KIRKLEES METROPOLITAN COUNCIL INVESTMENT & REGENERATION SERVICE

DELEGATED DECISION TO DETERMINE PLANNING APPLICATIONS

Reference No:	2025/62/90644/W
Site Address:	Mount View, Sheffield Road, New Mill, Holmfirth, HD9 7HA
Description:	Demolition of existing conservatory and erection of single storey rear extension, erection of replacement garage, porch to front elevation, and associated external alterations
Recommending Officer:	Molly Storer

DECISION – CONDITIONAL FULL PERMISSION

Neil and Angela Bellas Mount View, New Mill			
drawn by	checked by	date	scale @ A1
MC	MC	04.03.25	1:100
Proposed House Alteratons and Garage			
Proposed Plans, Sections and Elevations			
project number	drawing number	revision	
116	210	A

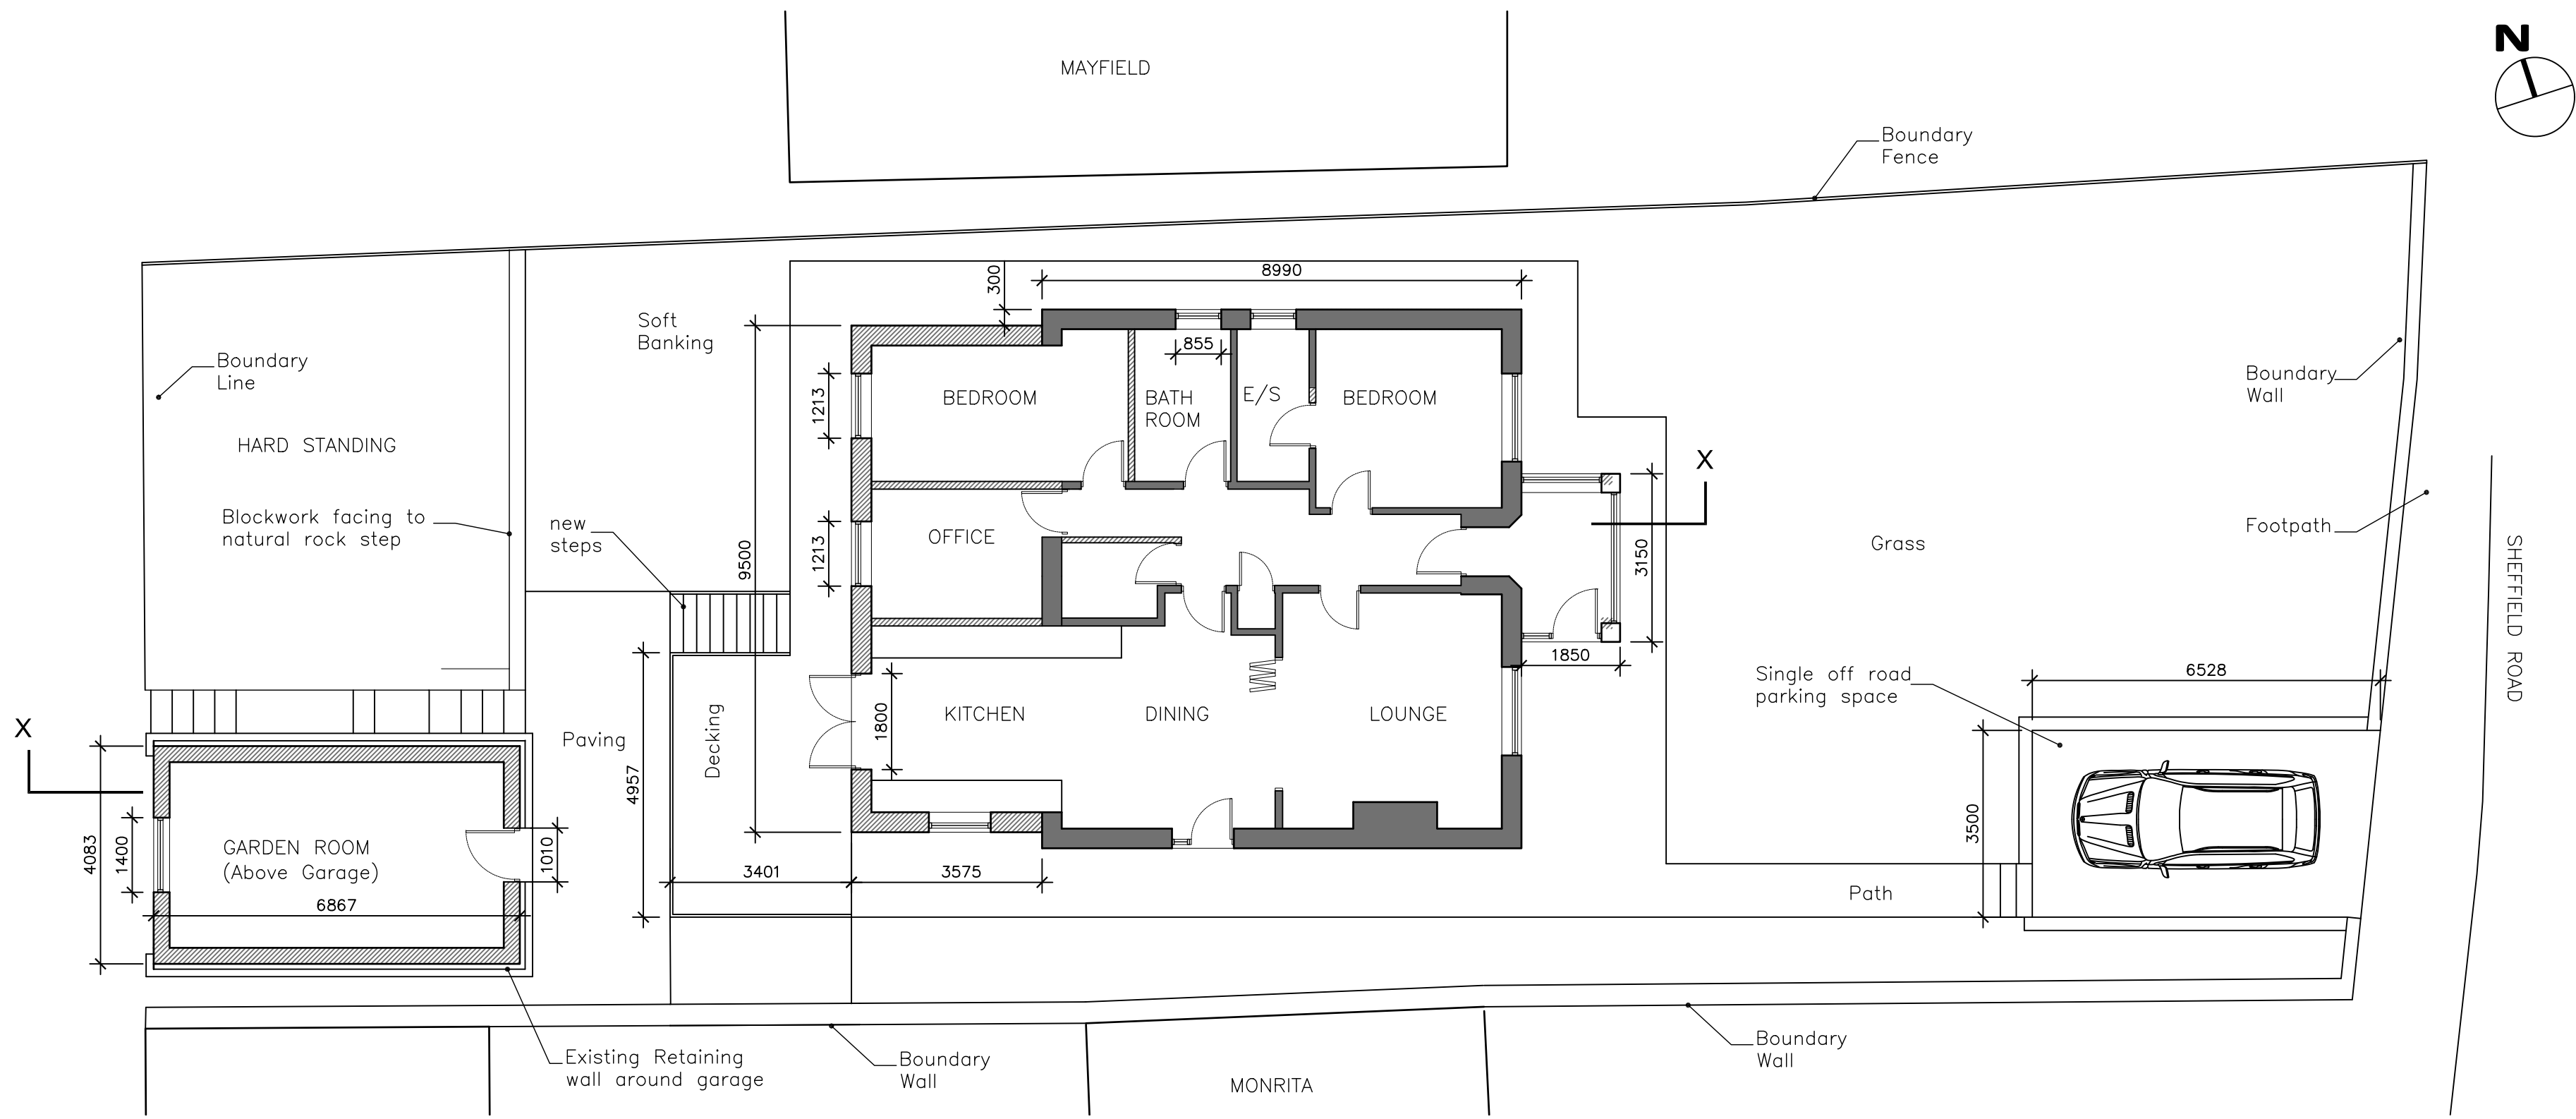
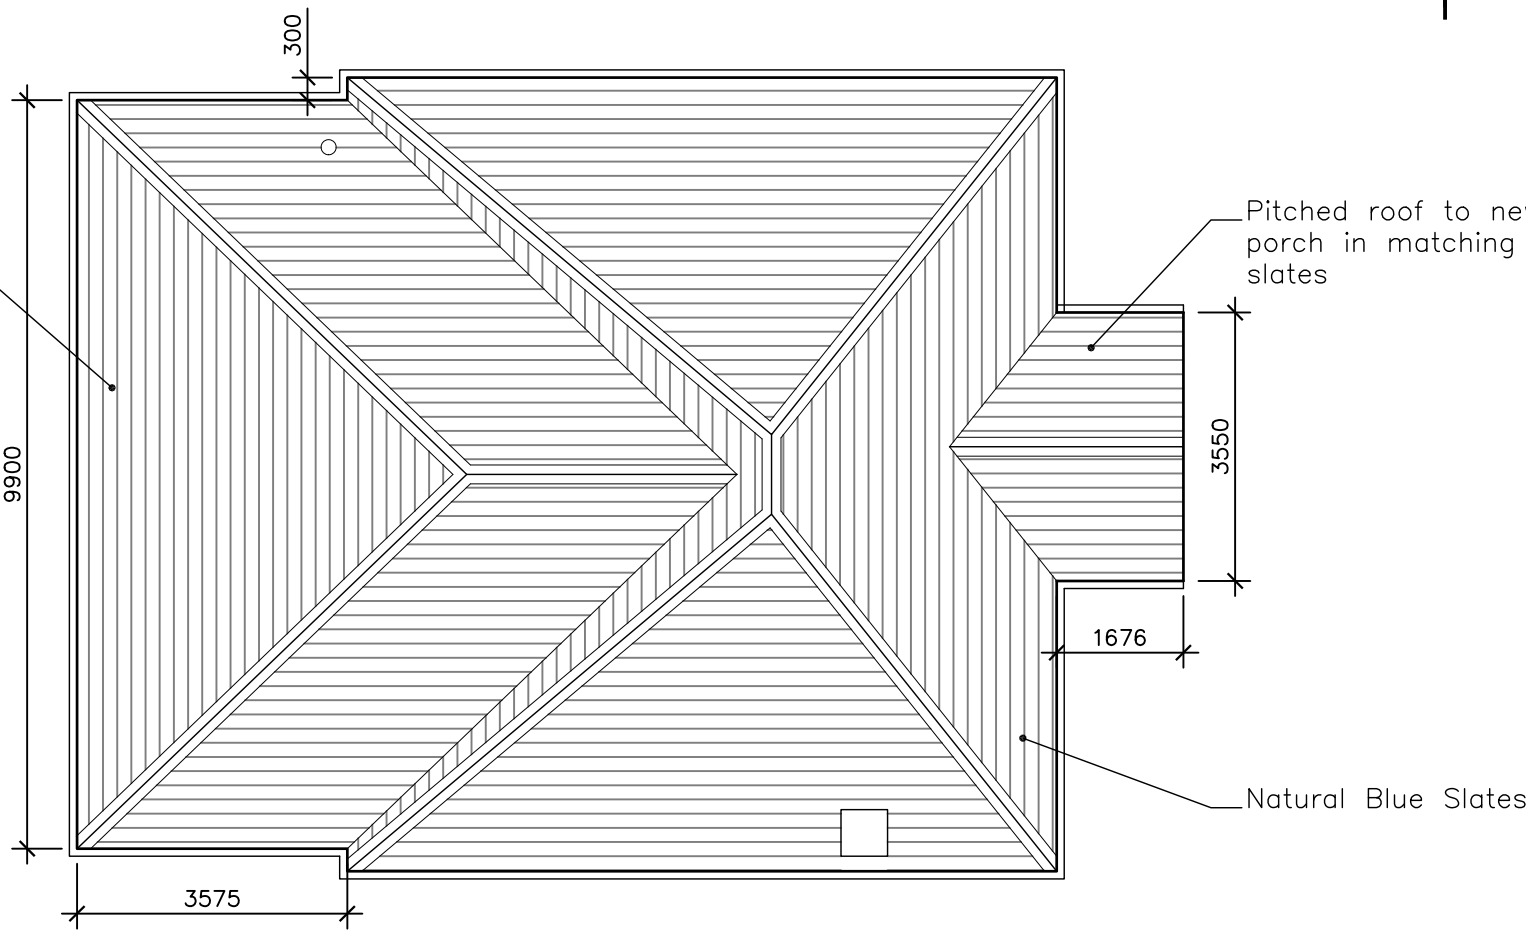
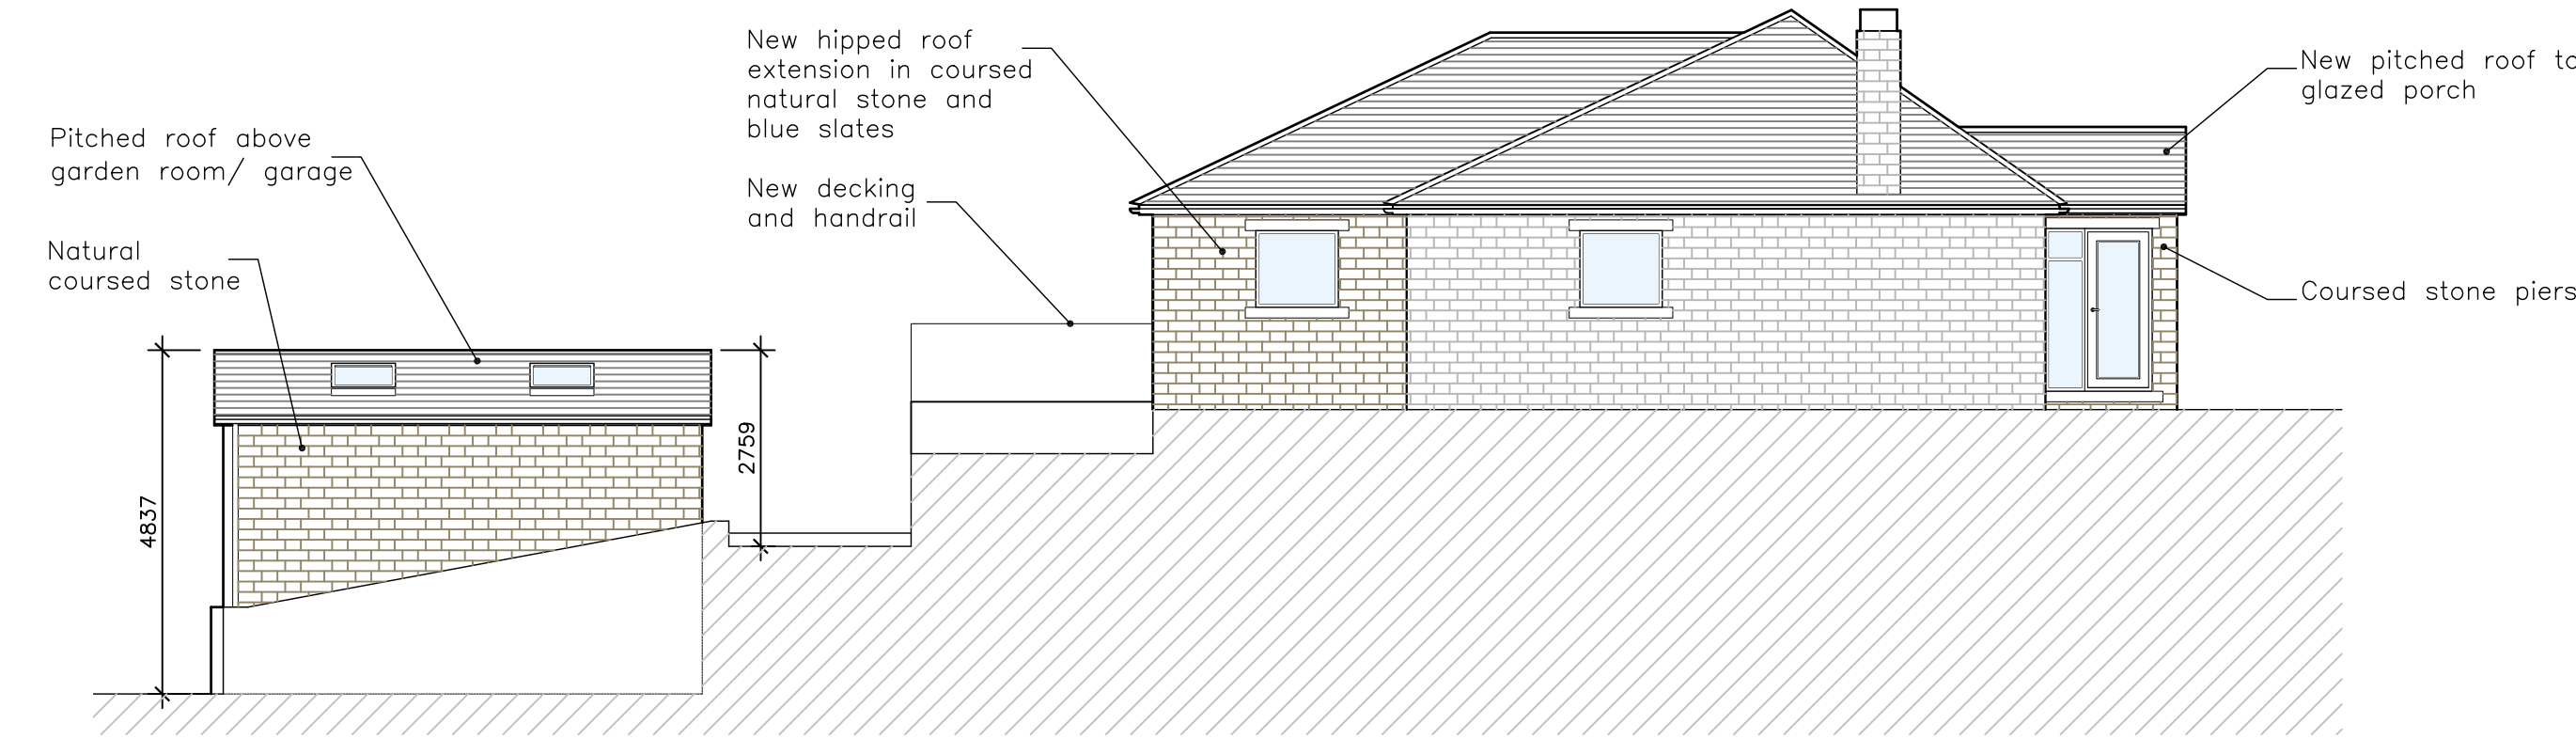
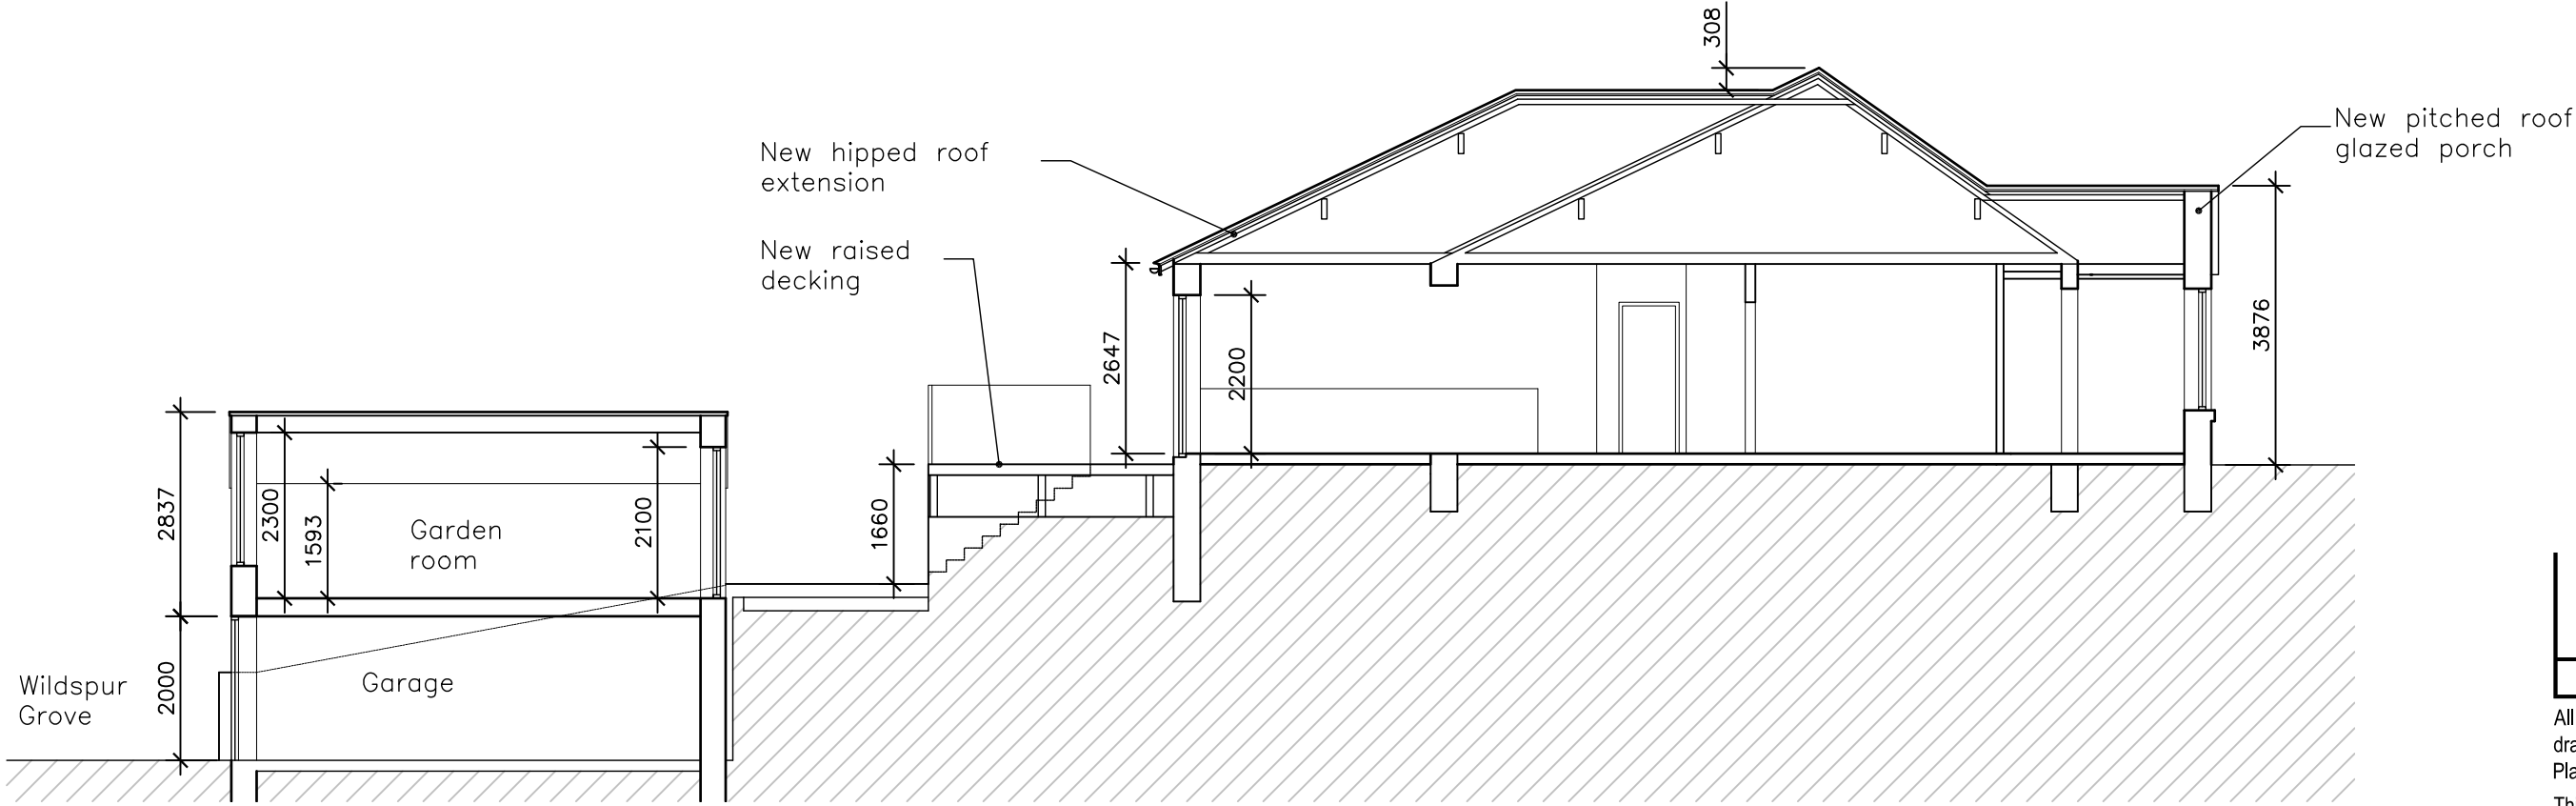
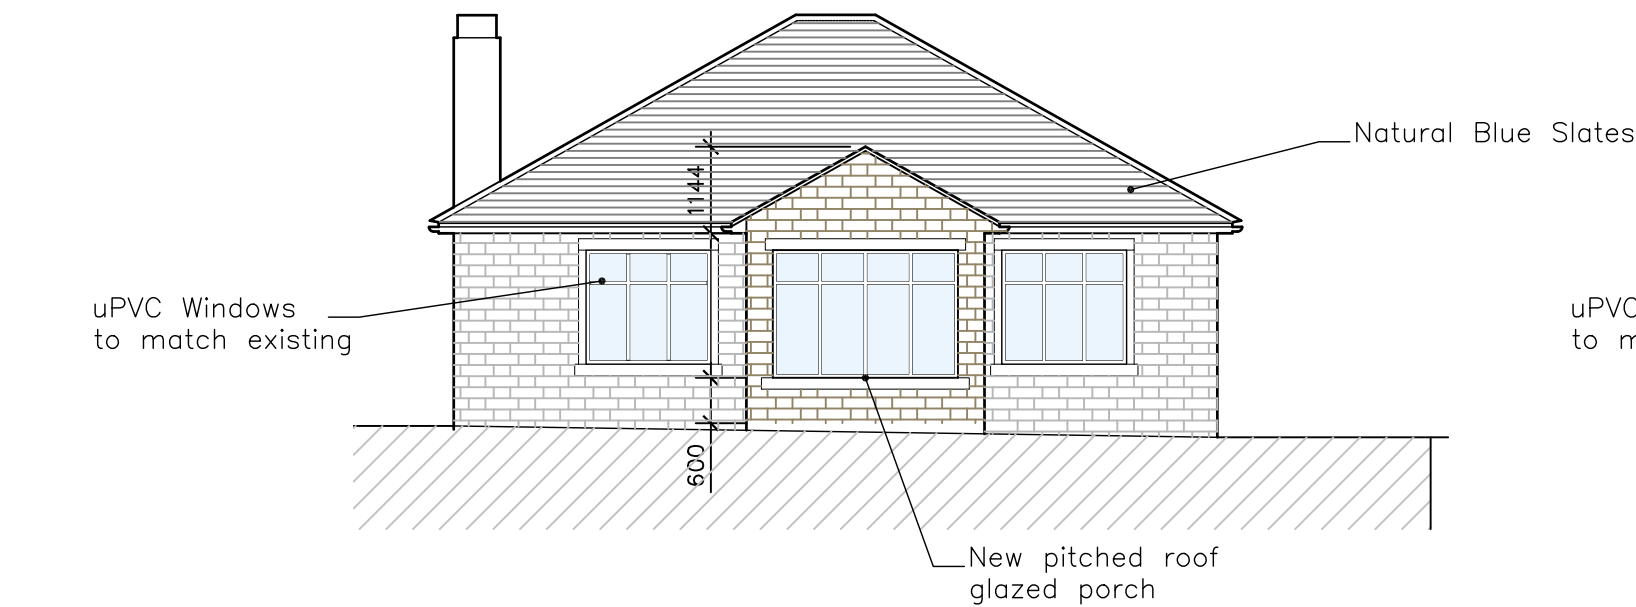
- 3.575m projection from the rear elevation
- 9.5m width
- 2.75m to eaves
- 5.2m overall height
- Hipped roof design with matching materials.

- 1.85m projection from the front elevation.
- 3.15m width
- 2.8m height to the eaves
- 3.9m overall height
- Gable roof design

With regards to the proposal the rear extension will exceed 4m in height however, due to the property being a bungalow and the extension being set down from the original roof ridge and set in from either side elevation in this instance this is considered acceptable. The house is detached and the projection will be less than 4m and there will be more than a 1m gap to each side boundary. Therefore, although the extension is not wholly SPD compliant on balance this is considered acceptable.

The porch extension would be small in terms of size and scale and would be well set back from the highway by around 14m. It would have a limited overall height of 3.85m and would have a gable roof design to match the garage. It would be set well away from neighbouring properties and is therefore considered acceptable.

Whilst the width of the porch is of a size which may not be visually acceptable in other circumstances, in this case weight is afforded the space which would remain in relation to neighbouring properties and also the fact the porch would be of a similar size, scale and design as that which has been undertaken to the immediate neighbouring properties.

Whilst there would be an additional window in the elevation facing this property, there would remain a separation distance of 3m to the boundary wall and 8.5m to the conservatory at Monrita. It is noted that this would cause some level of overlooking to this conservatory however it is not considered to be significantly higher than current levels of overlooking which could take place from the

conservatory at Mount View. There would be no windows within the side elevation of the garage or the porch (only a single door with a separation distance of 6m to the boundary mitigating any impacts). The garage would be screened by the double garage at this property and would not be largely visible from the rear garden of Monrita. The decking would be accessed via steps from Wildspur Grove and would be used to access the rear elevation. This decking would be on the same level as the rear elevation which is the existing situation. Therefore, although this would be coming further forward it is not considered to have any significantly additional impact.
